Rezoning Transportation Analysis

Petition Number: 2022-136

From: Jake Carpenter, PE

Date	Description
1-25-23	First Review (TM)
02-22-23	Second Review (TM)

SITE PLAN

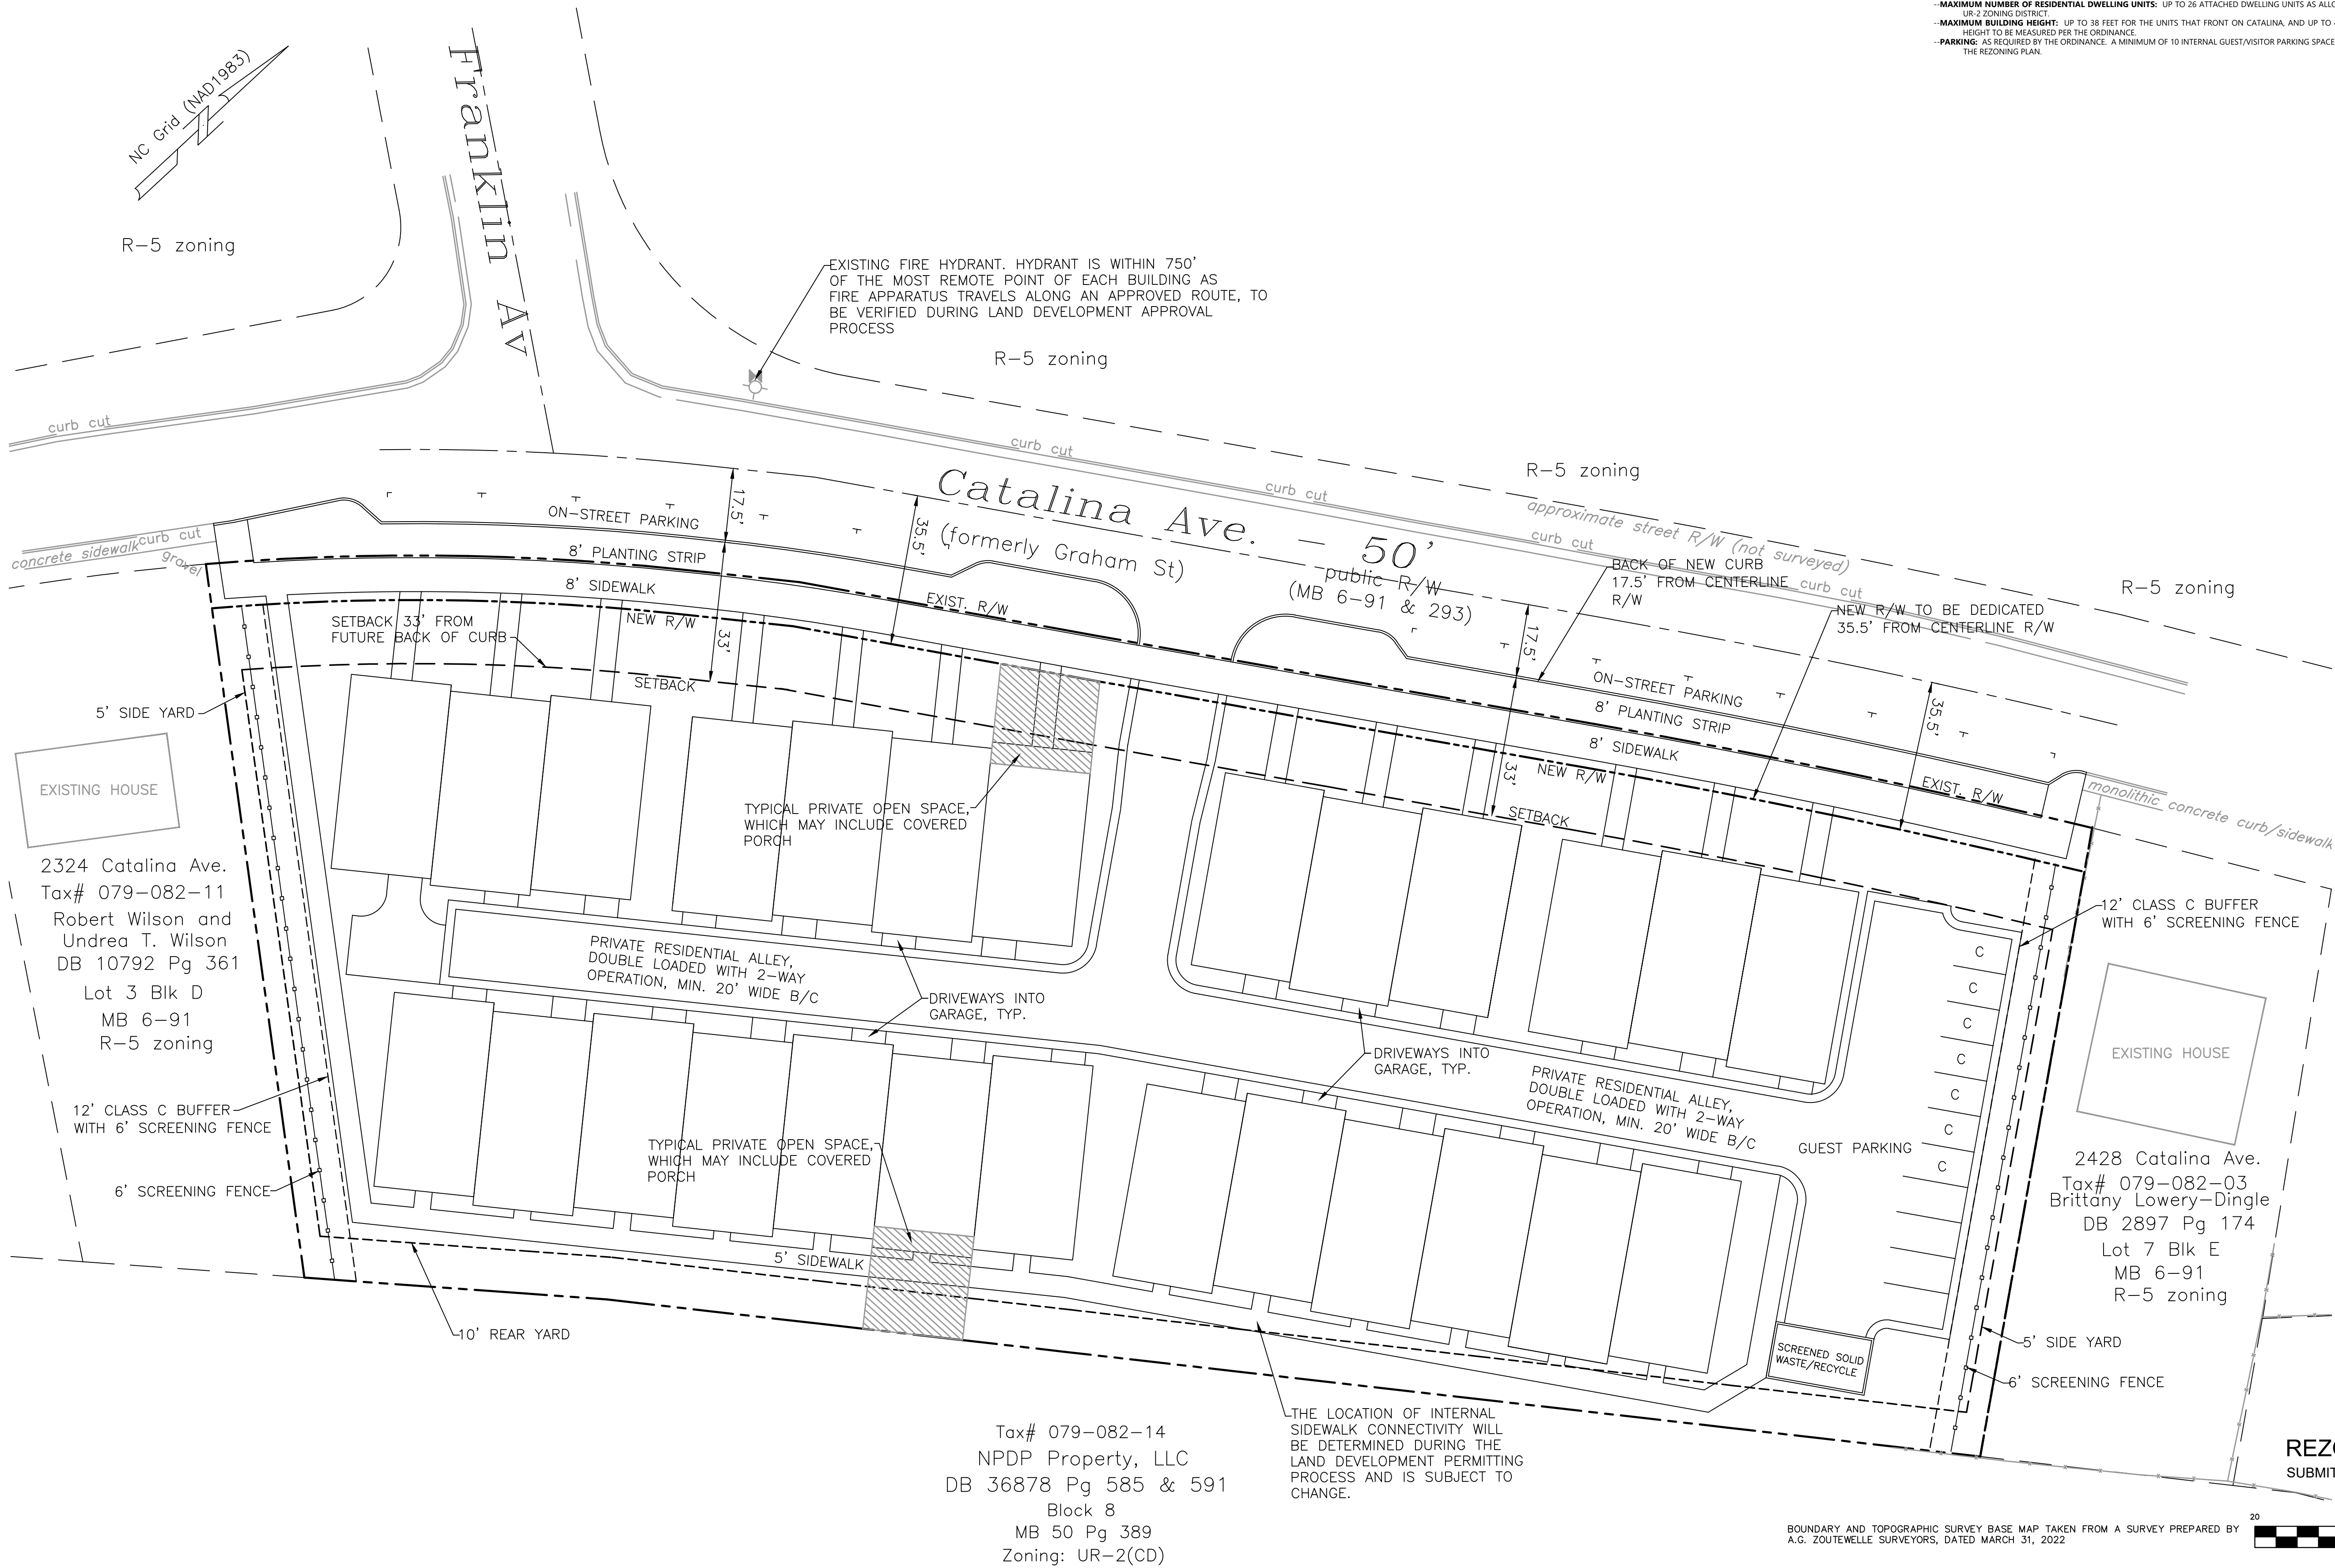
Label and dimension the curb and gutter from the centerline for each road on the site plan.
